FULL

Reference:	H16-0960-17	Date of Decision:	21st November 2018
Applicant:	Delicija Unit 2 20 Westlode Street Spalding Lincs PE11 2AE		
Location:	Unit 2, 20 Westlode Street Spalding Lincs		
Description:	Replacement ramp access and associated works

Proposed Balustrade

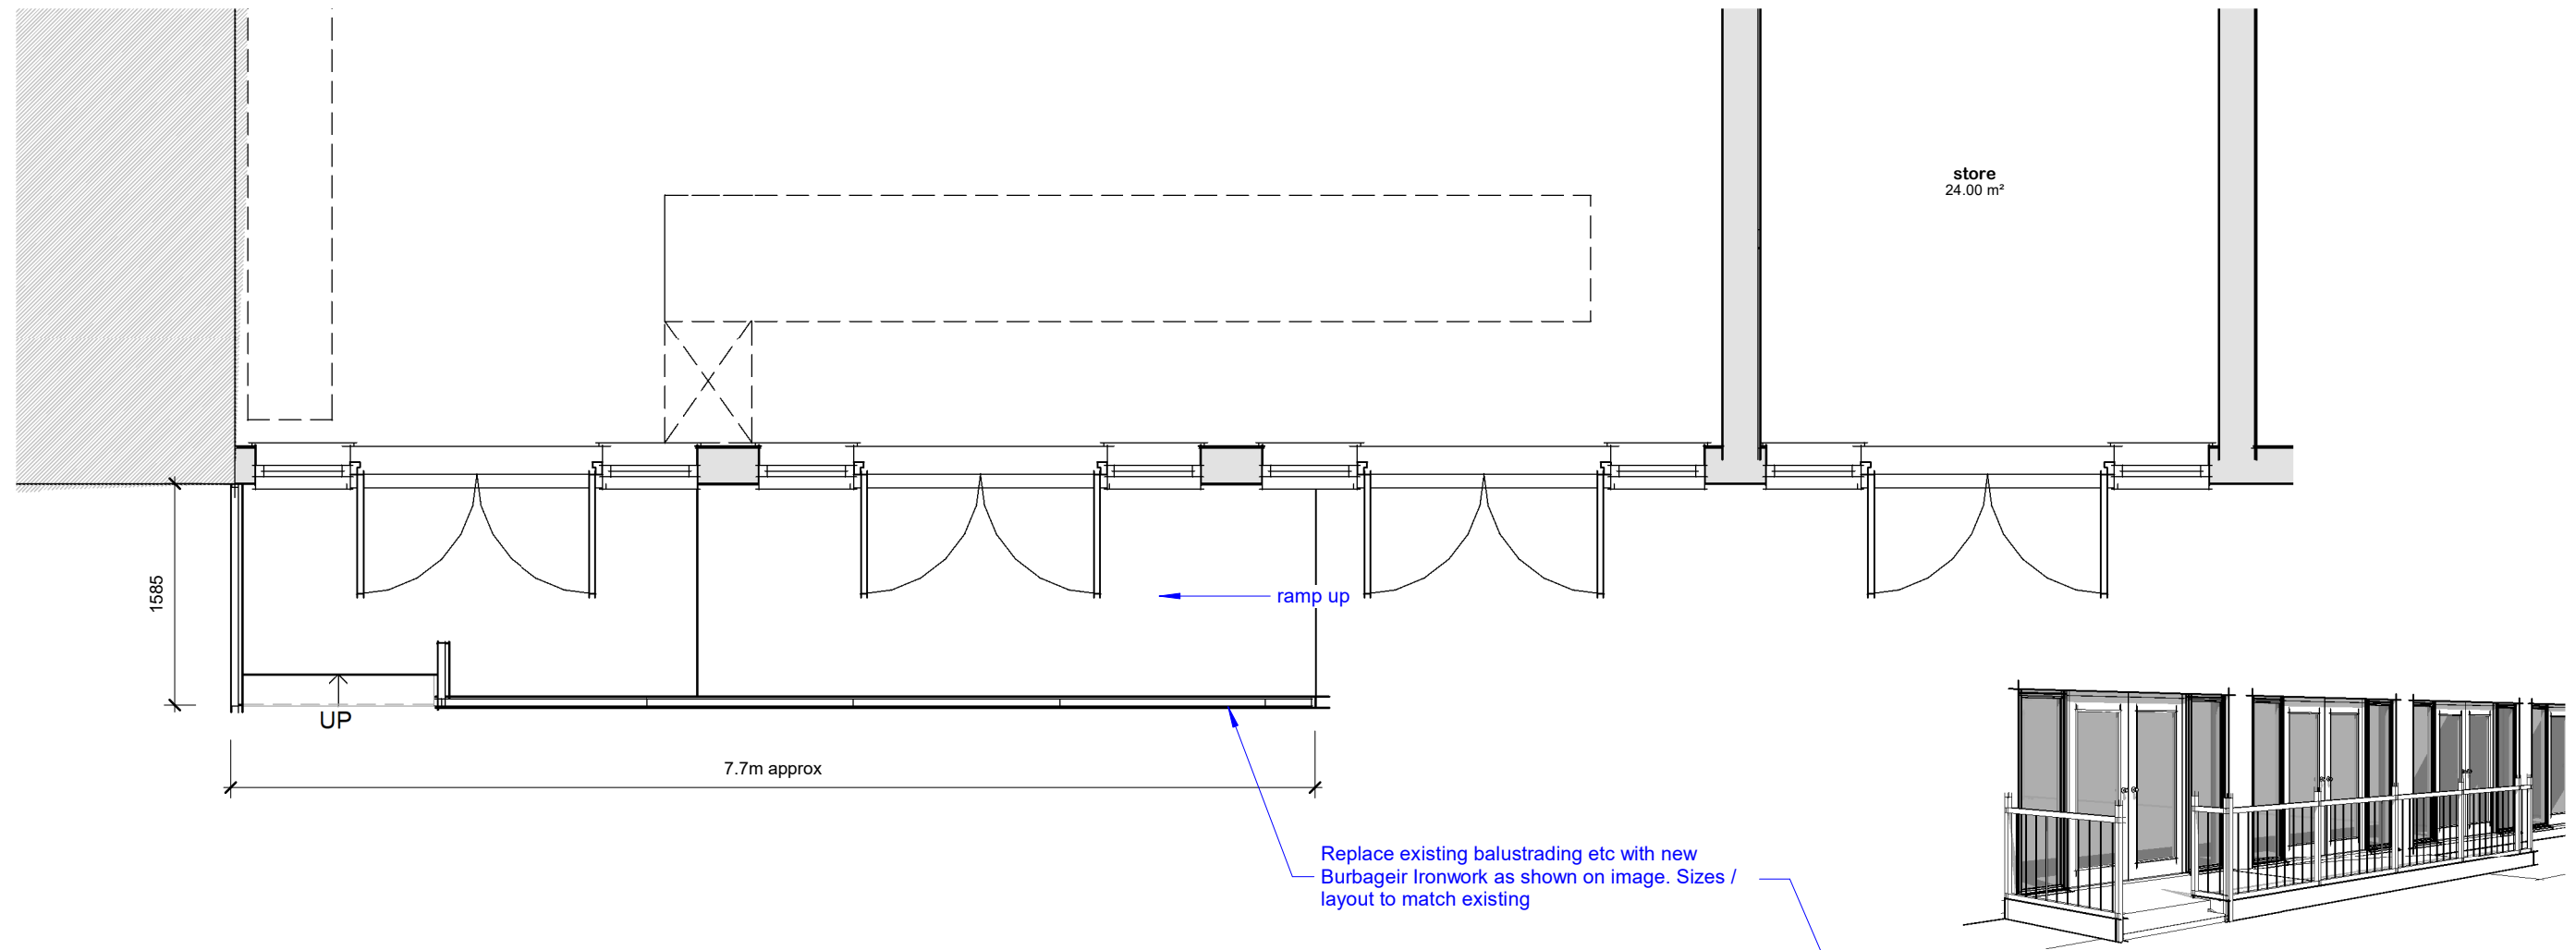
- 1 The structure which has been installed is not acceptable in terms of the visual amenity and character of the Spalding Conservation Area.

The structure is of a highly visible and unsympathetic design that would detract from the visual qualities of the Conservation Area.

Lincolnshire County Council as Highways Authority have confirmed it protrudes into the public highway and object to the application.

The structure presents an unacceptable intrusion into the publicly adopted highway and

presents a hazard to highway safety and to highway users particularly pedestrians.
